Grindleton Parish Council response to planning application for the Duke of York Grindleton

In the application there is a request for change of use on the public house known as the Duke of York.

FIRST FLOOR PLAN

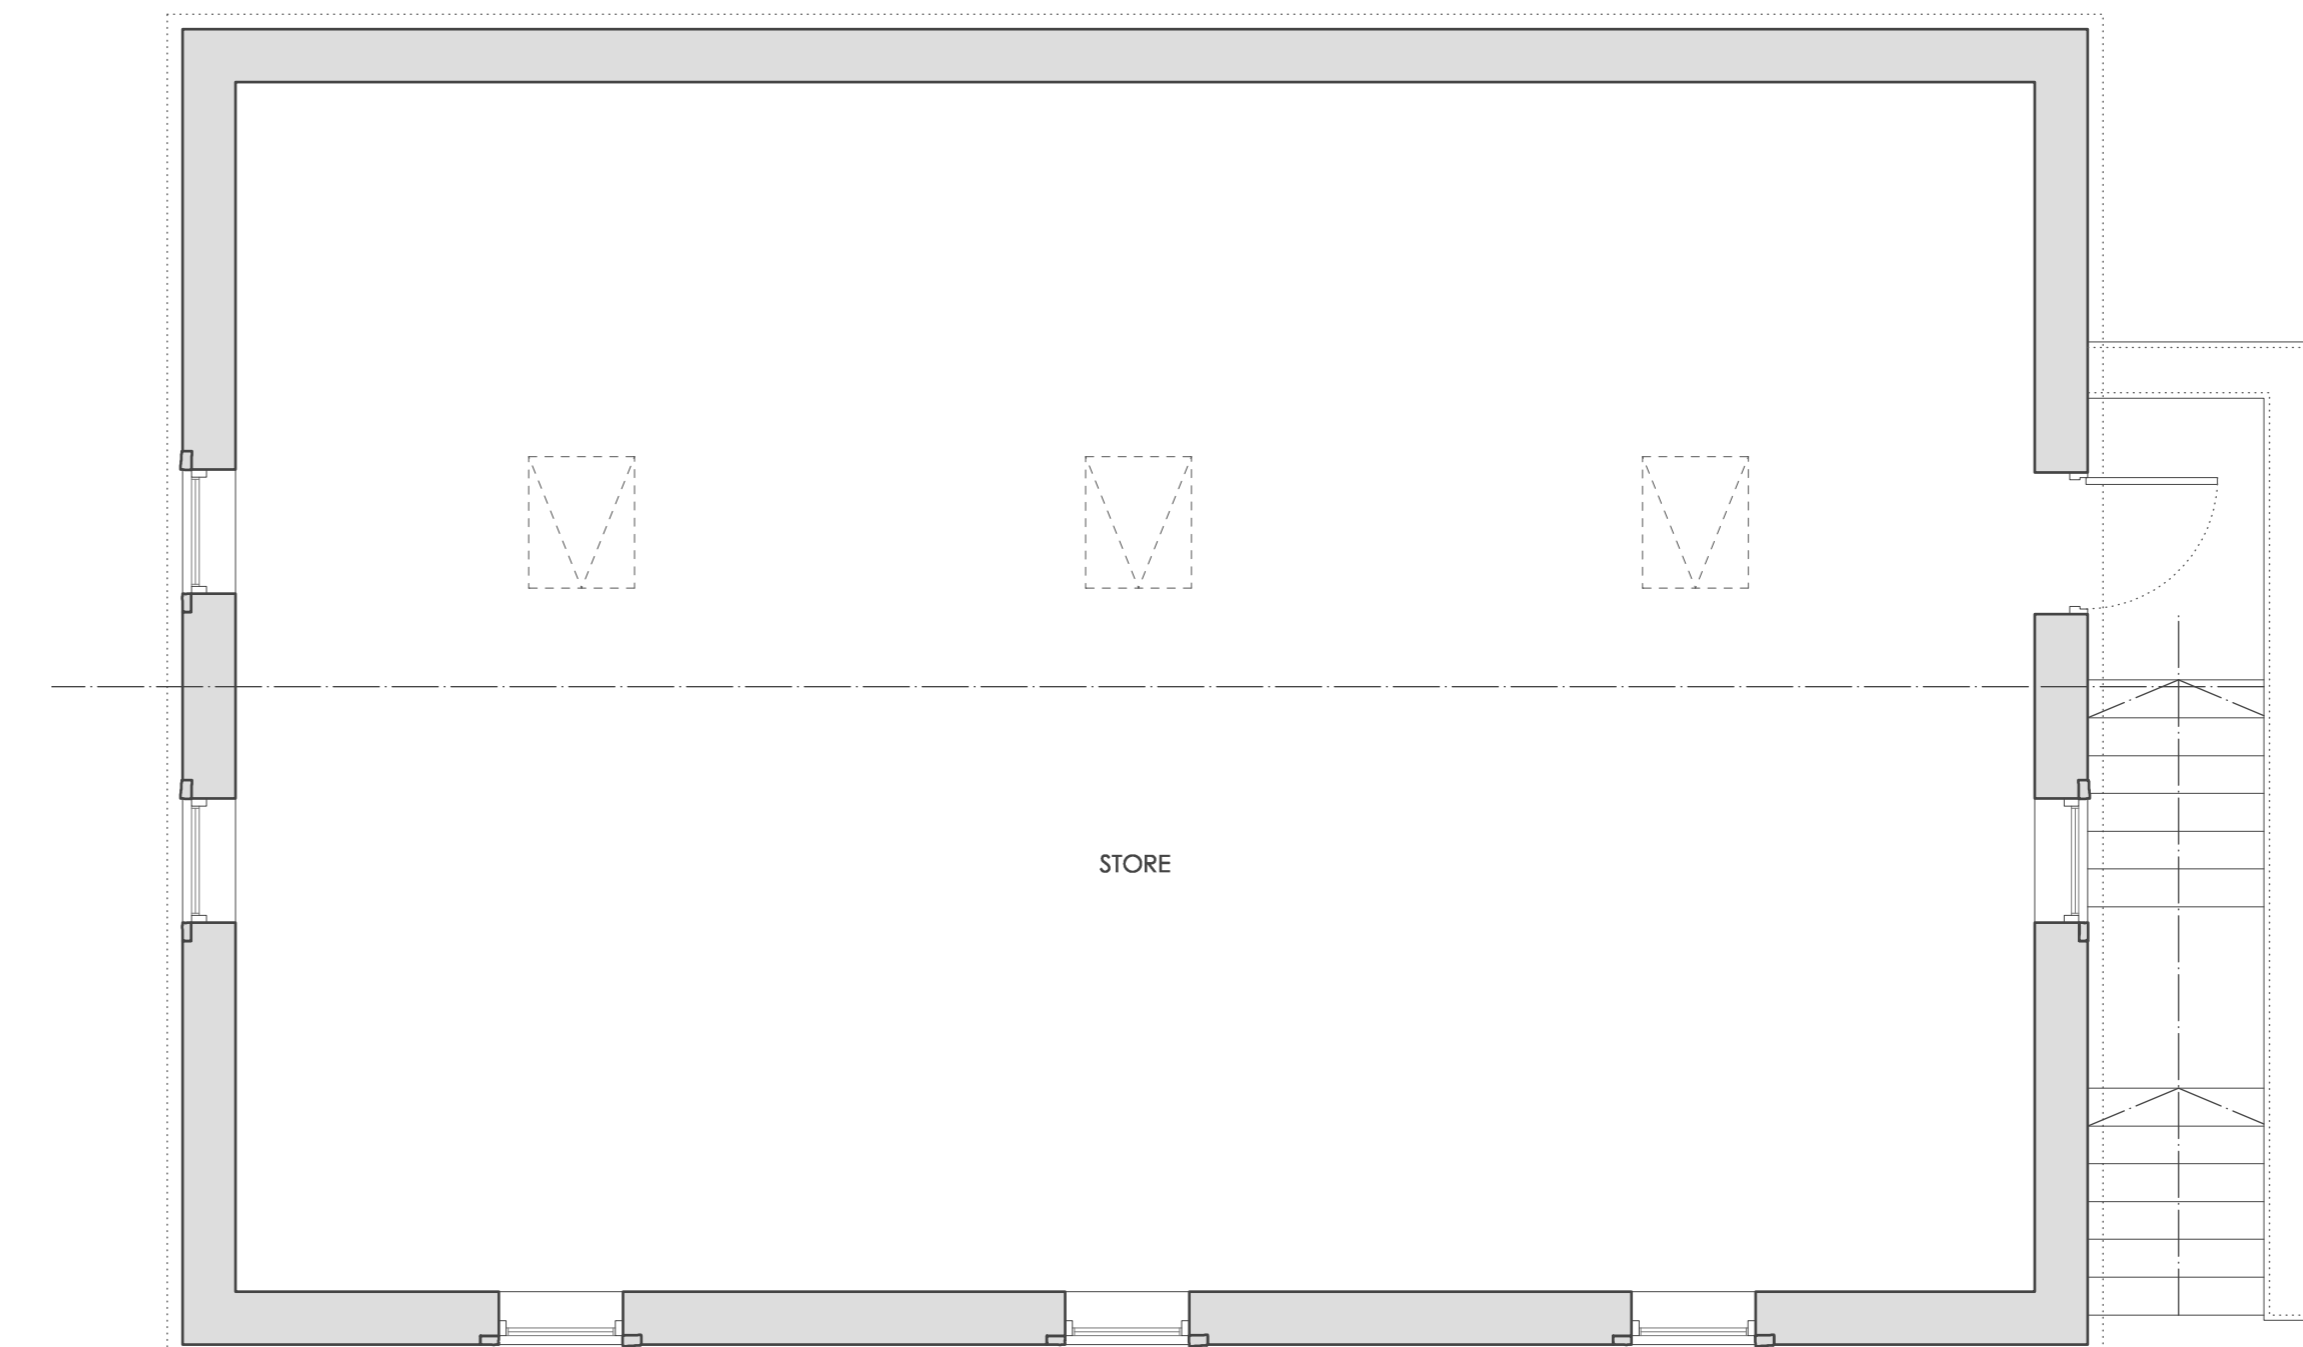
Firstly, in the application it states the building will be a workshop and a store and a depot. If it is a workshop more noise than the application indicates will be generated. If it is a depot this implies it will be used for storage of building materials, sand, stone etc. this would be totally unacceptable due to noise and increase in HGV traffic within the conservation area.

Whilst we agree that a public house created noise that was mainly at given times of the day, with a builder's store this could be from early morning through to late at night. Not with holding this, in the winter will flood lighting be used at unsociable times to light the loading area? Considering the site has houses on two of its boundaries this would be undesirable. The application does say that ladders and scaffolding will be kept in the store. These are noisy when being moved around.

In the application the information says the 1st floor will be used for storage of equipment that they don't want to leave on site. At this stage I would like to add a statement from one of our councillors who has worked in the industry.

"In my 45 years of construction experience and current health and safety legislation of manual handling regulations. I find it surprising a store has been designed where tools, materials and heavy equipment must be carried negotiating a flight of external stairs of at least 16 treads on a regular basis. This equipment can vary significantly from light to very heavy and perhaps a two-person lift. If materials are to be stored as suggested (copper tube etc) then negotiating the limited landing space would be hazardous"

As the store will be used to store high value items we have concerns as to how they intend to apply their security. We would want a restriction on 24/7 flood lighting and at unsociable times.

The builders store is going to be built alongside millennium woods which has been developed over the years to attract wildlife and grow native plants. This is an area that is well used by the villagers. It is felt that the woods would be adversely affected by excessive use of floodlighting from within the depot.
